From: Bruce Taunton
Sent: 20 November 2009 09:51
To: Planning.Responses
Subject: RE: Planning Consultation on: K/22/09/

APPLICATION NO: K/22/09/

Registered: 23-OCT-09
Site Address: Chelsfield 53 Coastal Road East Preston BN16 1SN

Description of Works: Construction of third floor extension with flat roof, first floor balcony access to sun deck, garage extension, additional driveway parking & boundary wall erected to front of property

Notes

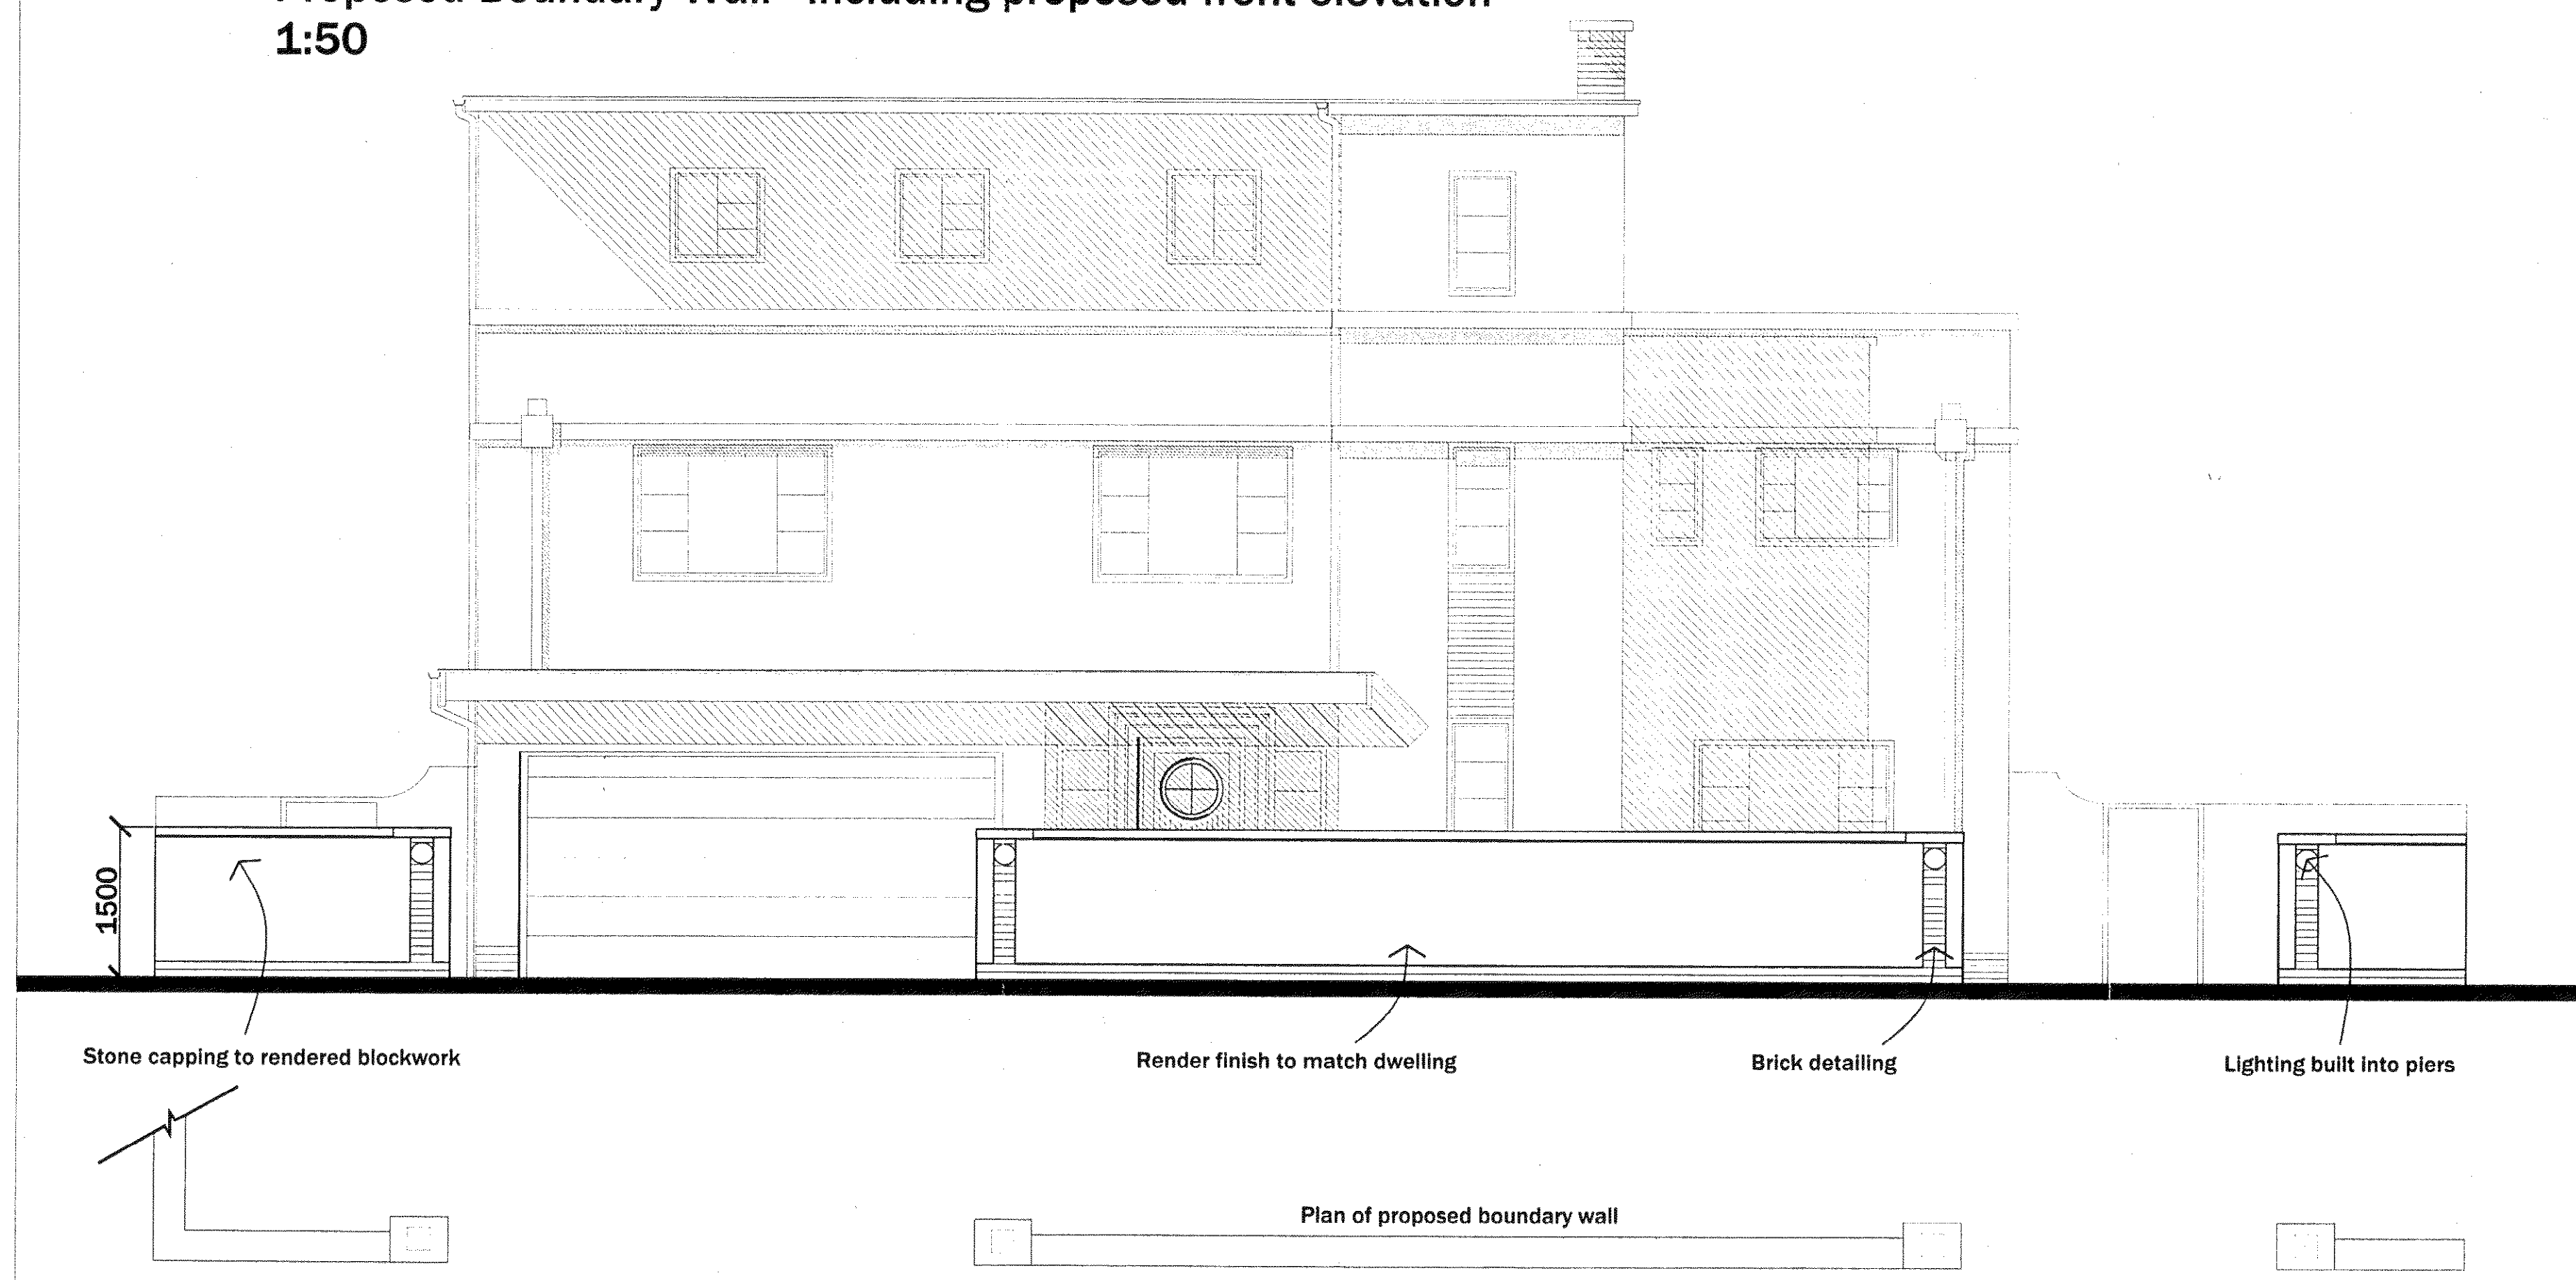
Depending upon the boundary wall thickness and design, there may be a need for an extra pier at the middle of the central portion of the proposed boundary wall. All other structural queries will be covered under the Building Regulations and we therefore have no other comments.
